## KITTITAS COUNTY COMMUNITY DEVELOPMENT SERVICES

April 6, 2007

### RE: Sage Short Plat, File #SP-07-12

VICINITY MAP

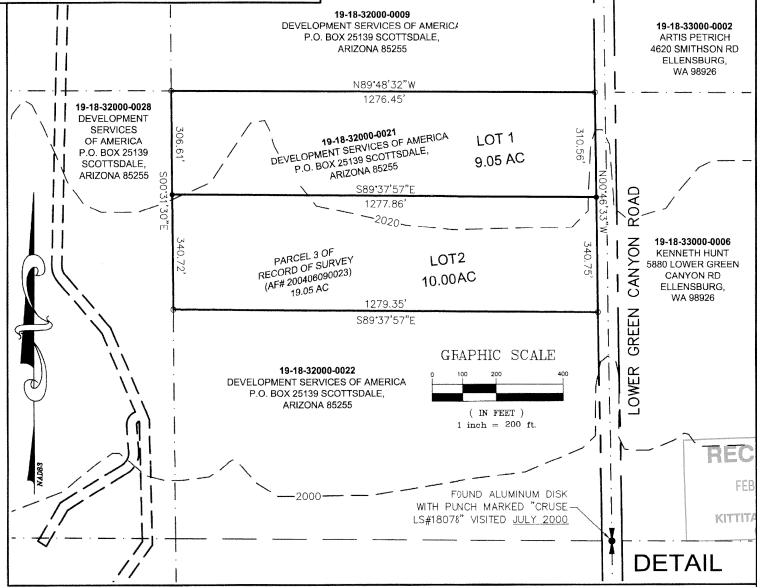
6. Vicinity map showing the boundary lines of all adjacent subdivisions shall be reflected on the mylars.
7. This property is within the boundaries of the KRD and both parcels contain irrigable ground. The applicant will need to comply with the requirements set forth in the KRD General Guidelines prior to approval from KRD and prior to final approval of the short plat.

SHORT PLAT NO. **????**
KITTITAS COUNTY, WASHINGTON

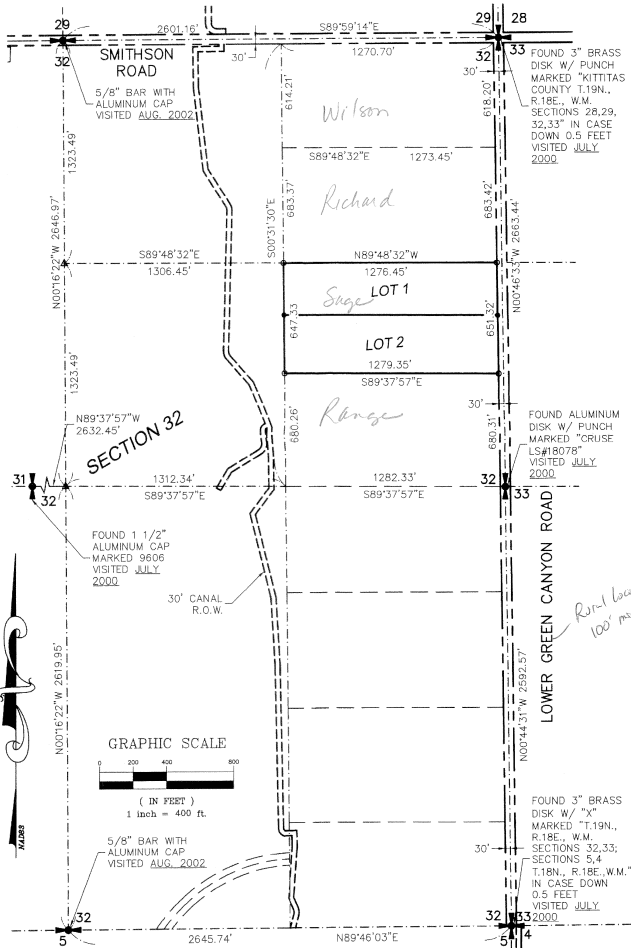
1. Both sheets shall reflect the short plat number SP-07-12.
2. Both sheets shall have location of subdivision by section, township, range, county, and state.

3. Actual acreage of lots on face of plat map.
4. Page one shall reflect the short plat map.
5. A statement regarding the contemplated sewage disposal, water supply, and drainage improvements for the proposed subdivision shall be reflected on the final mylars.

11. Both lots of the Sage Short Plat have a PEMC wetland across the west end of the property. The Final mylars shall reflect the location of this wetland and a statement on the plat shall read as follows: "Future development of lots may require a study by a certified wetland biologist to determine wetland classification and for buffer requirements pursuant to KCC Critical Areas Code."
